TOWN AND COUNTRY PLANNING ACT 1990 AGRICULTURAL DETERMINATION

Reference: H14-0798-26 **Date of Decision:** 22nd September 2026
Applicant: Glen Pastures
Bourne Road
Guthram Gowt
Lincs
PE10 0BD
Location: Glen Pastures Bourne Road Guthram Gowt Lincs
Description: Siting of 2 containers - one for storage of agricultural machinery, the other for agricultural workers welfare facilities

Scale.	1 : 1250 / 1 : 500 at A1	Author.	S. Mack
Drawing Number.	422-REV1-02-PSP	Date.	27/08/26
Drawing Title.	Proposed Site Plan	Rev.	
Do not scale from this drawing.		Note.

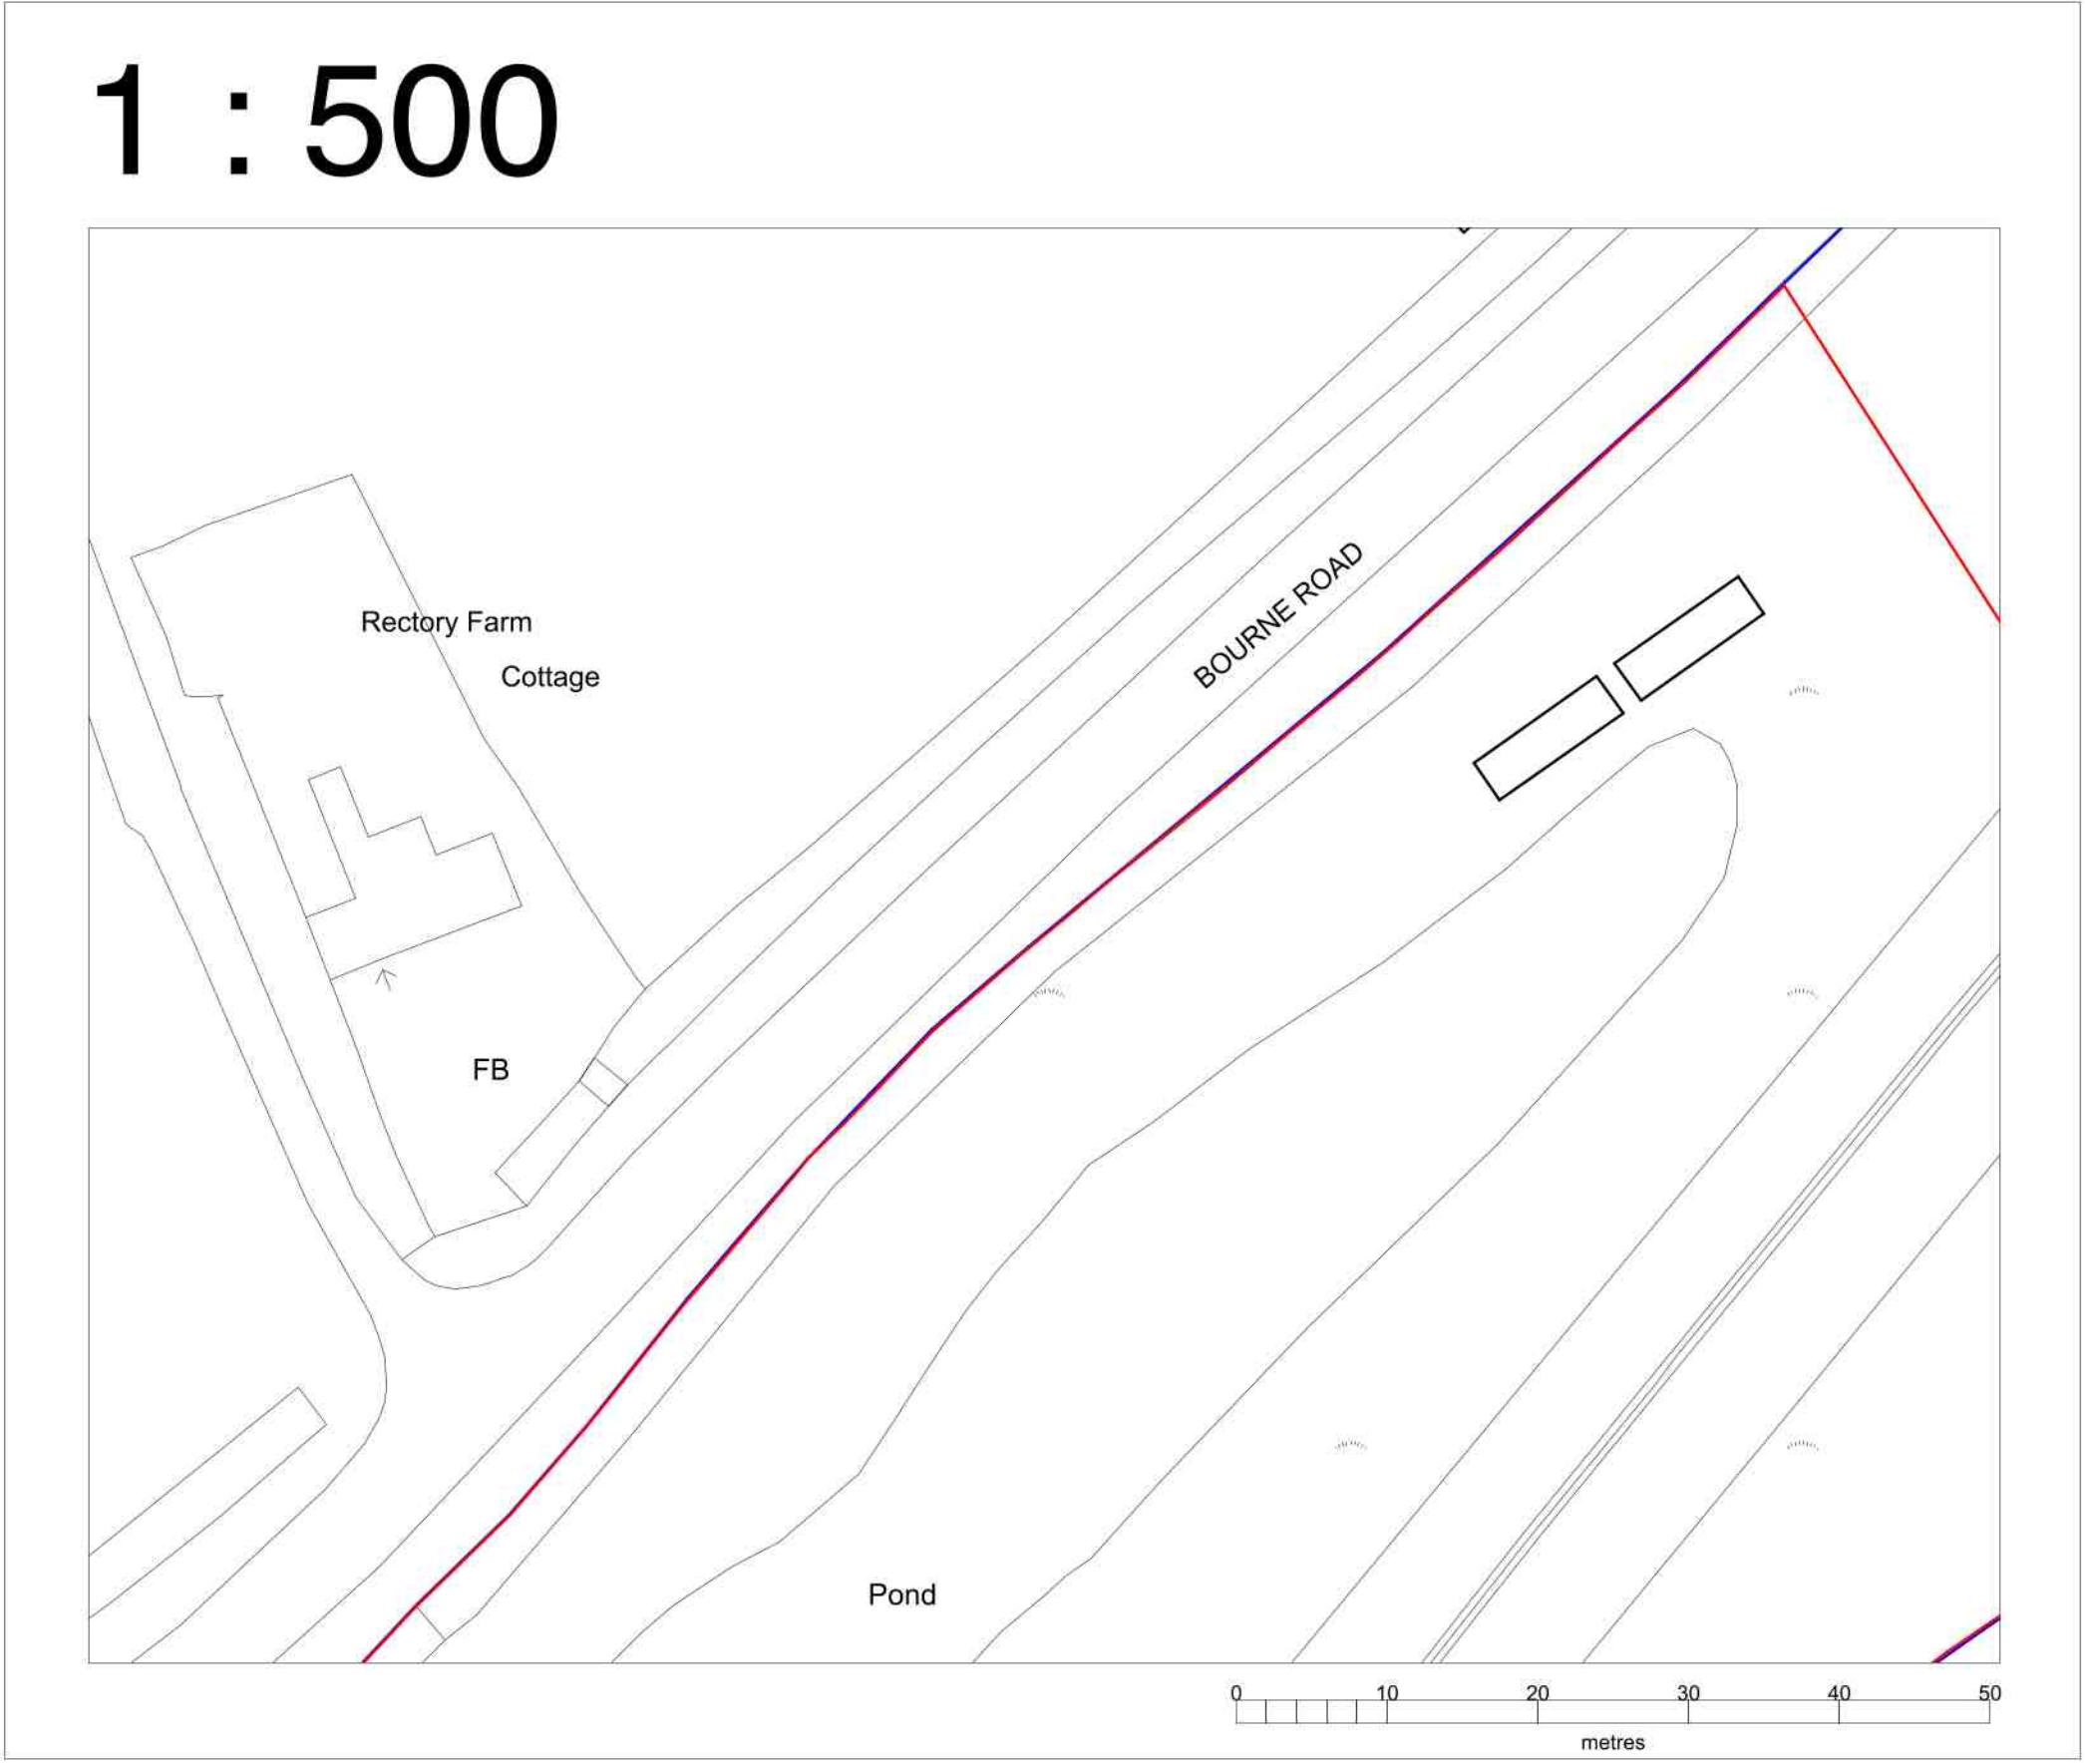
- 1 It is considered that the proposed containers would comprise chattels rather than buildings and as such, it is considered that the proposal is not eligible under Schedule 2, Part 6, Class A of the Town and Country Planning (General Permitted Development) Order 2015 (as amended).

Furthermore, one of the proposed containers has already been installed within the site and as such, the proposal has not complied with Condition A.2 (2) of Schedule 2, Part 6, Class A of the Town and Country Planning (General Permitted Development) Order 2015 (as amended).

Lastly, the containers would be positioned less than 25m from the A151 and as such, the proposal conflicts with one of the restrictions of Class A (A.1 part h).
